CITY OF ALBUQUERQUE

RE: **Campbell Compound**
Drainage Report and Grading Plan
Engineer's Stamp Date 9/26/17
Hydrology File: G13D032

Based on the information provided in the submittal received on 9/26/17 the above-referenced submittal cannot be approved for Preliminary Plat or Grading Permit until the following are addressed:

**SECTION Y-Y**  
SCALE: 1"=40' HOR.  
1"=10' VERT.

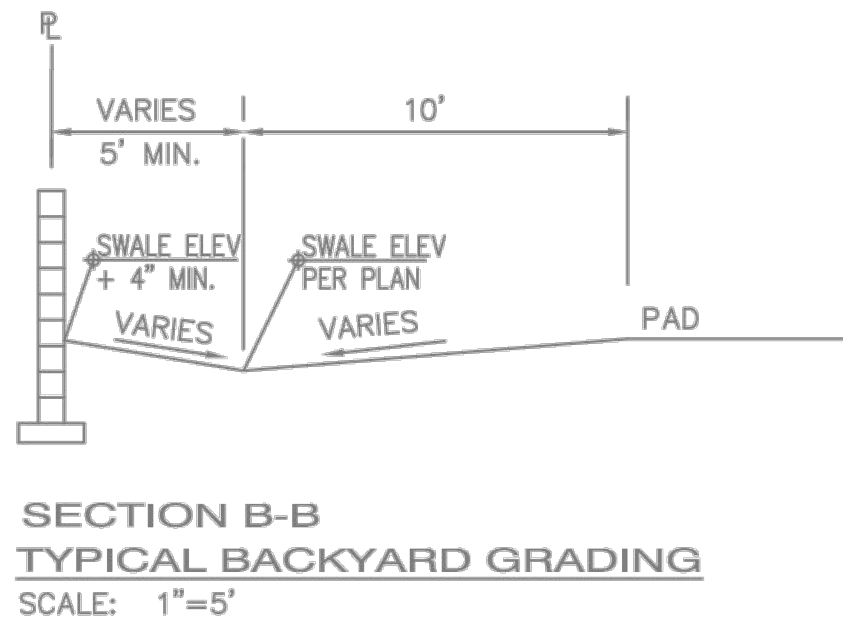
3. Separate Section F-F into two viewports for the different cases. Clearly show that the footer stays off the adjacent property.
4. Modifying an existing privacy wall into a floodwall is not an acceptable course. If a floodwall is desired, a new one will need to be designed and built (Section Y-Y).

DOUBLE RETAINING WALL  
SECTION E-E  
NTS

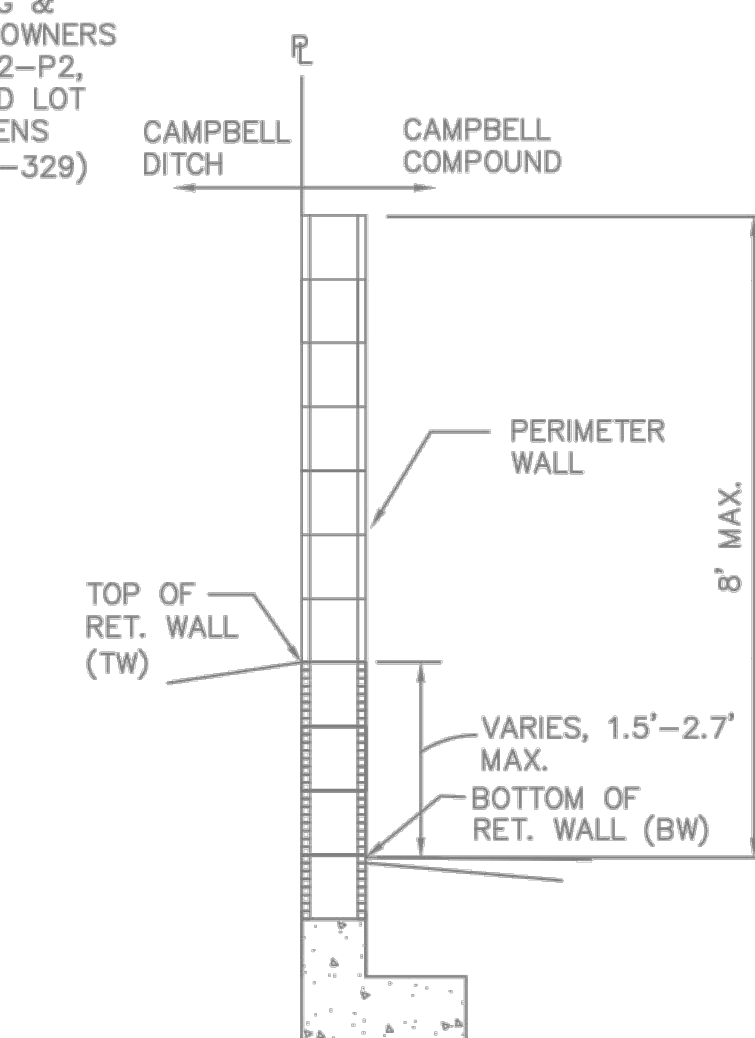
1. Subbasin A needs to include the Campbell Rd half street area and the ponds on tract B & C need to be sized to include this volume.
2. Section E-E on sheet 2/2 shows the retaining wall/privacy wall encroaching across the property line. Correct to show on only Campbell Compound's property.

SINGLE RETAINING WALL  
SECTION G-G  
NTS

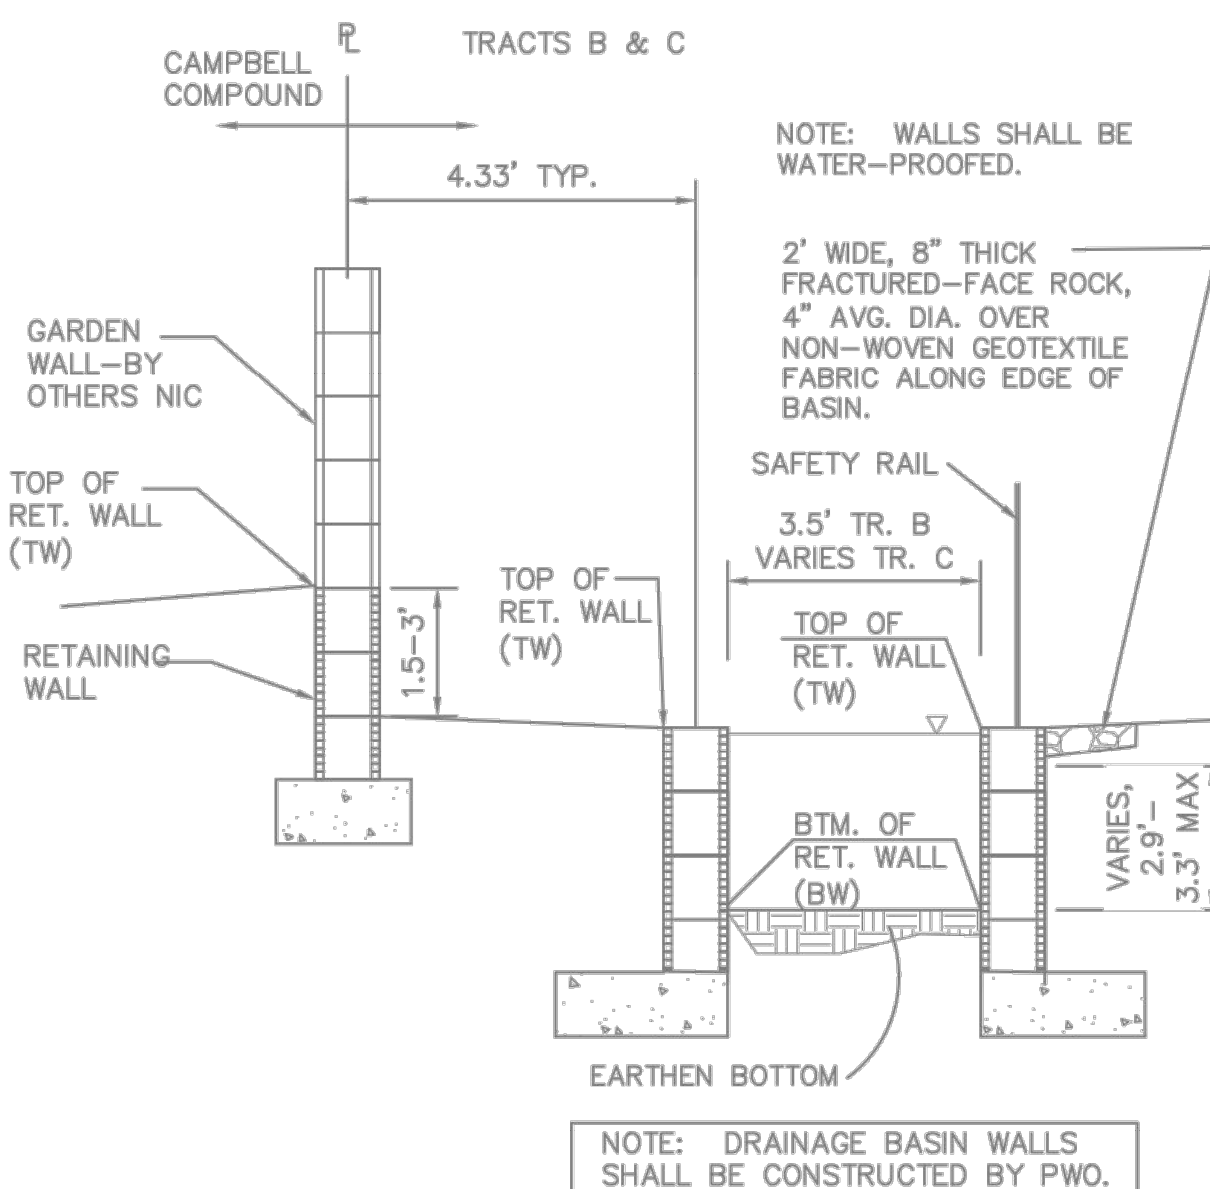
5. Modifying an existing privacy wall into a retaining wall is not an acceptable course. A new wall will need to be designed and built (Section G-G).
6. Written permission from Campbell Farms HOA will need to be obtained, authorizing any modifications to the common wall. If portions of the wall are owned/maintained by Campbell Farms Lot 11, written permission from that homeowner will be needed as well.

7. the rear-yard retaining wall needs to be 4" (minimum) above the high point of the rear-yard swale invert to promote drainage away from the rear wall and to the front yard (Section B-B and G-G).
